Date: 29 January 2025  
Your Ref: EN010125/IP No. 20050058  
Our Ref: 17996

**IP NO. 20050058 – WRITTEN REPRESENTATIONS ON BEHALF OF NET ZERO NORTH SEA STORAGE LIMITED**

**EN010125 – APPLICATION BY RWE RENEWABLES UK DOGGER BANK SOUTH (WEST) LIMITED & RWE RENEWABLES UK DOGGER BANK SOUTH (EAST) LIMITED FOR AN ORDER GRANTING DEVELOPMENT CONSENT FOR THE DOGGER BANK SOUTH OFFSHORE WIND FARMS**

DRAWING TITLE  
**Offshore Order Limits & Grid Co-ordinates**

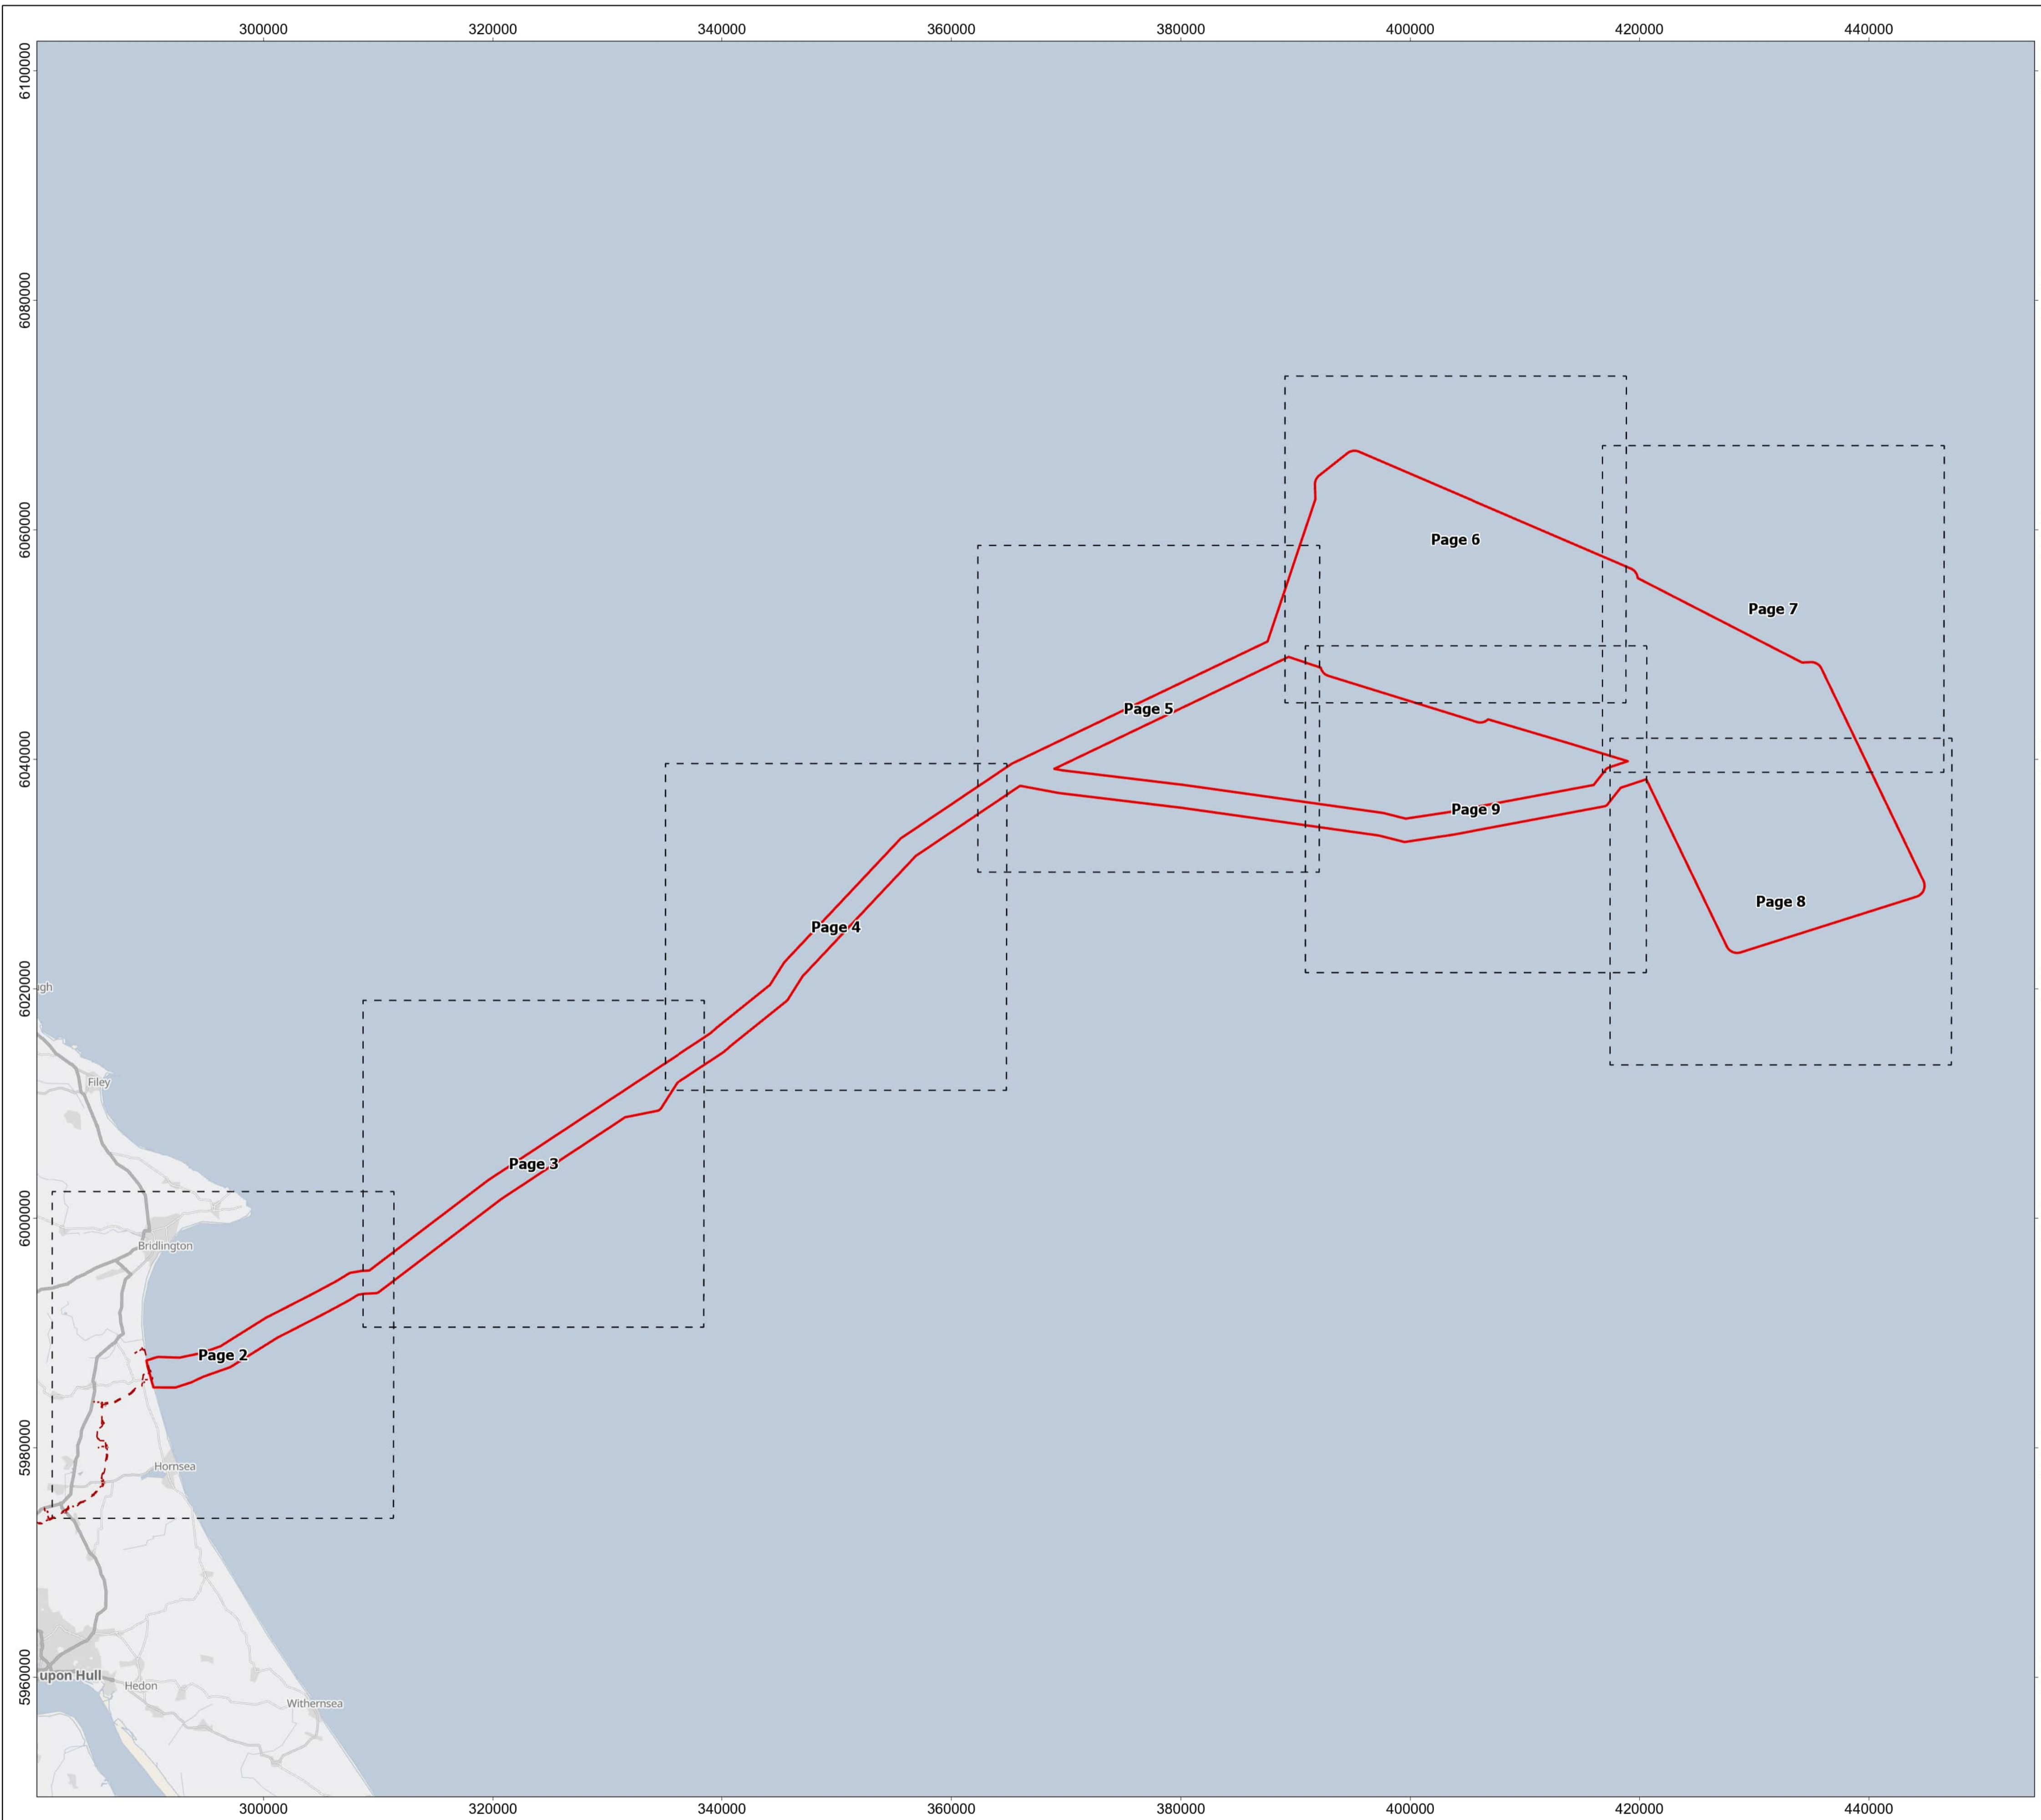
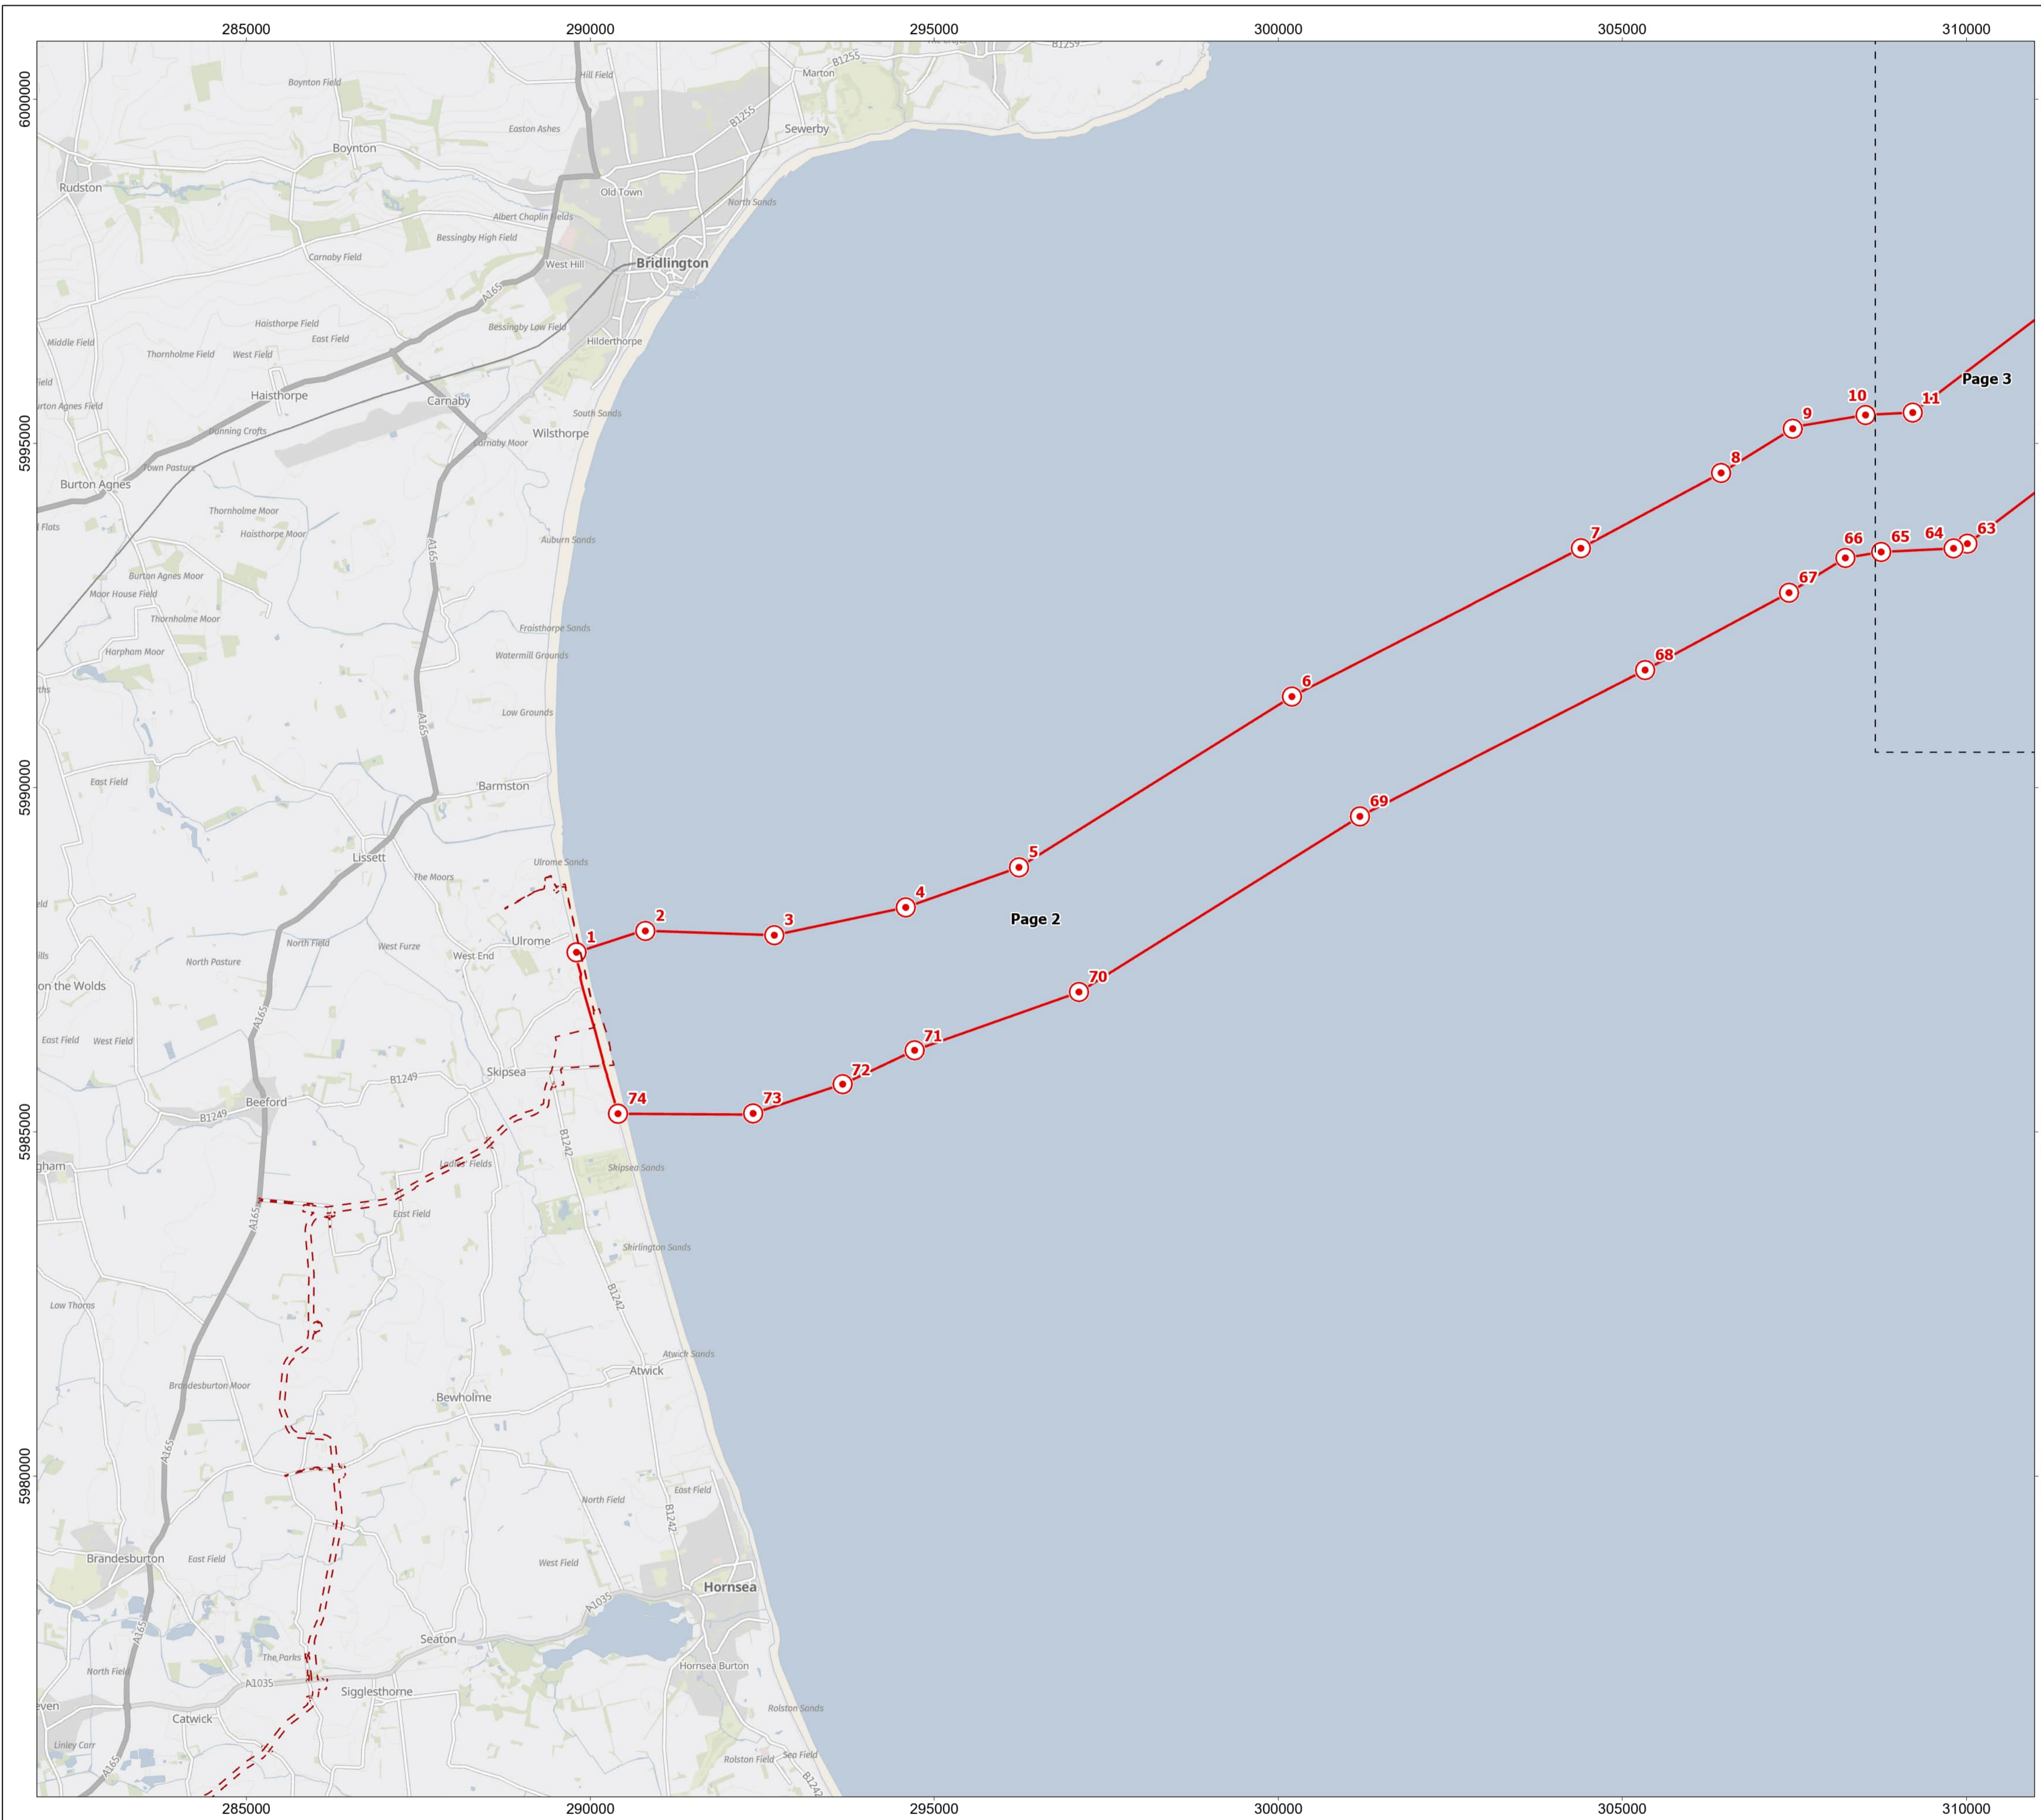
The Land and Works Plans that form part of the Application indicate that the electrical cable corridor for the Proposed Development will cross the Teesside pipeline. In addition, the southern routing of the electrical cable corridor will cross the CS025 Storage Licence area where NEP is developing a further carbon dioxide store.

Having reviewed a number of the key application documents, NSNZS is concerned as to the lack of detail within the Application on how the interactions of the electrical cable corridor with the Teesside pipeline and the CS025 carbon dioxide store will be managed and any impacts mitigated.

NZNSS needs to see further information as to the construction methods that RWE proposes to cross the Teesside pipeline and the carbon dioxide store and how construction and other impacts will be minimised and mitigated in order to ensure that it is satisfied that there will be no adverse effect on the NEP infrastructure and its operations.
